ENTECH
ENGINEERING, INC.

Re: Soil, Geology, and Geologic Hazard Study - Addendum
7020 Wyoming Lane
Tax Schedule No. 53080-00-105
Colorado Springs, Colorado

Ref: Soil, Geology, and Geologic Hazard Study, April 5, 2022
Jaynes Property
Poco Road and Vollmer Road
El Paso County, Colorado
Entech Job No. 212381

Colorado Geological Survey Review, September 15, 2022
Jaynes Property Sketch Plan
El Paso County, Colorado
County File No. SKP225

GEOLOGY/ENGINEERING GEOLOGY MAP  
JAYNES SITE  
POCO ROAD & VOLLMER ROAD  
EL PASO COUNTY, CO.  
FOR: ELITE PROPERTIES OF AMERICA

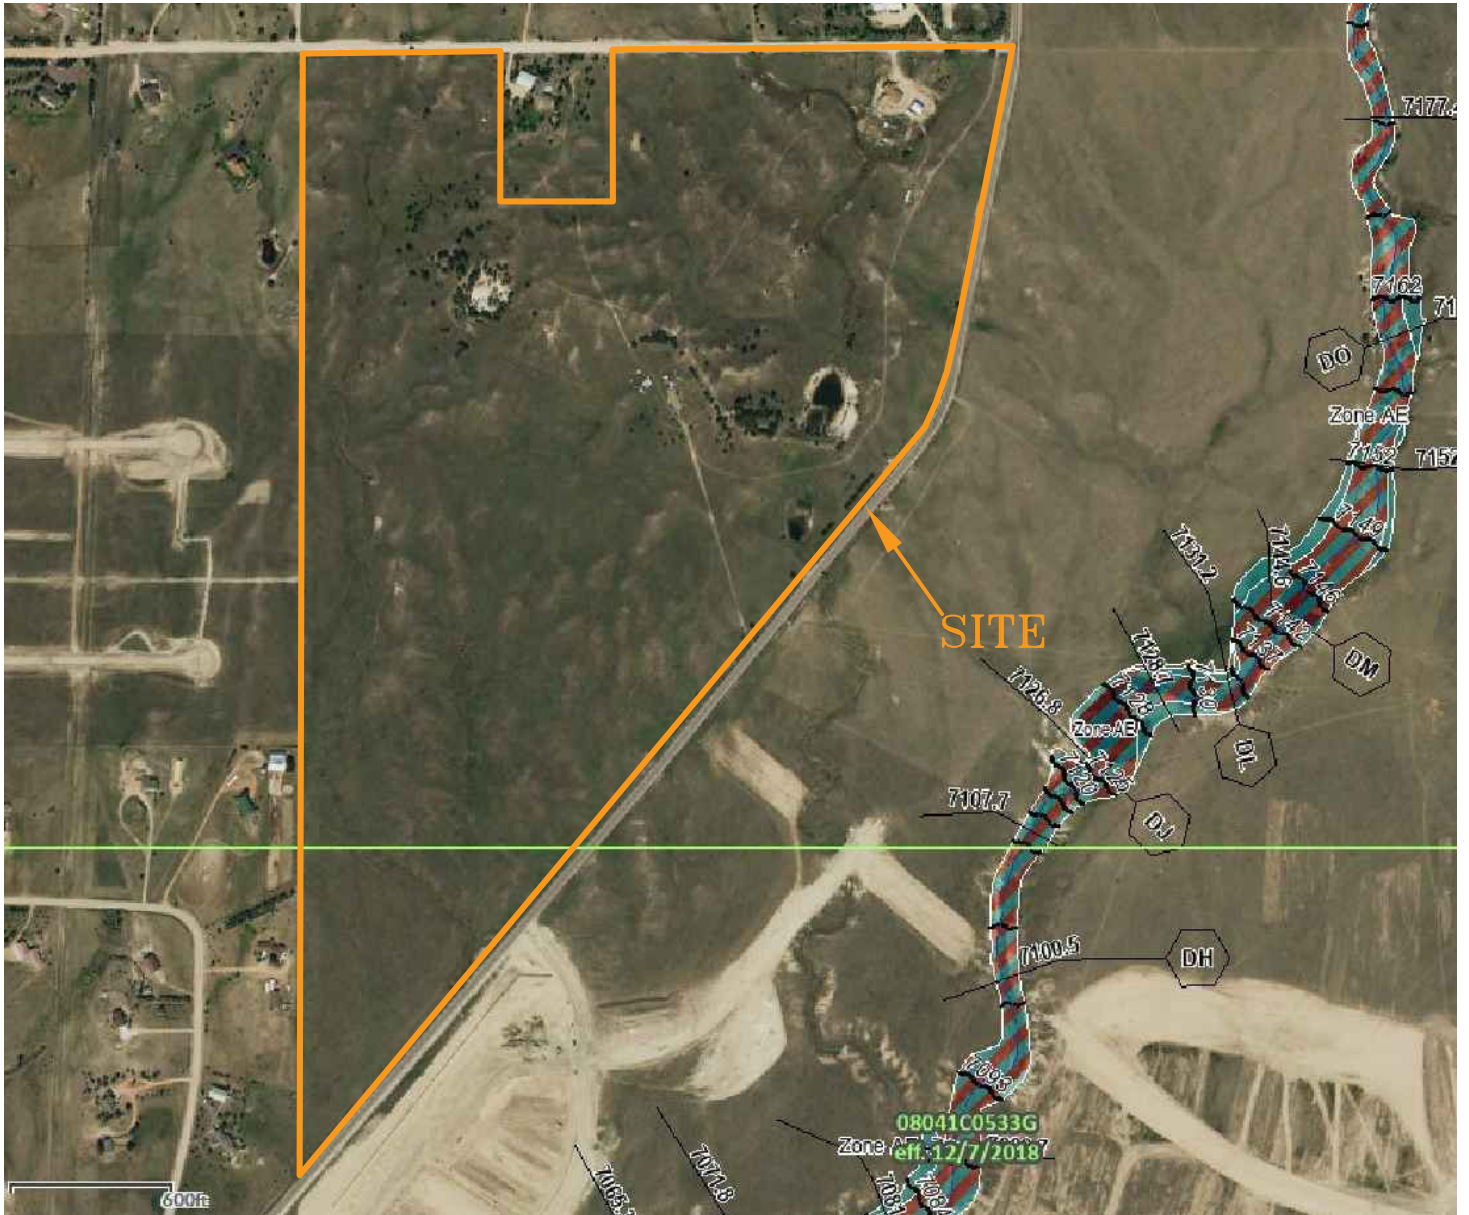
CGS Comment: *“CGS recommends that Entech consider adding legends to the maps to clarify what the numbers represent.”*

Entech Response: The maps Figures 3 and 7 have been revised to clarify bedrock and groundwater depths presented on the maps, and are included with this letter.
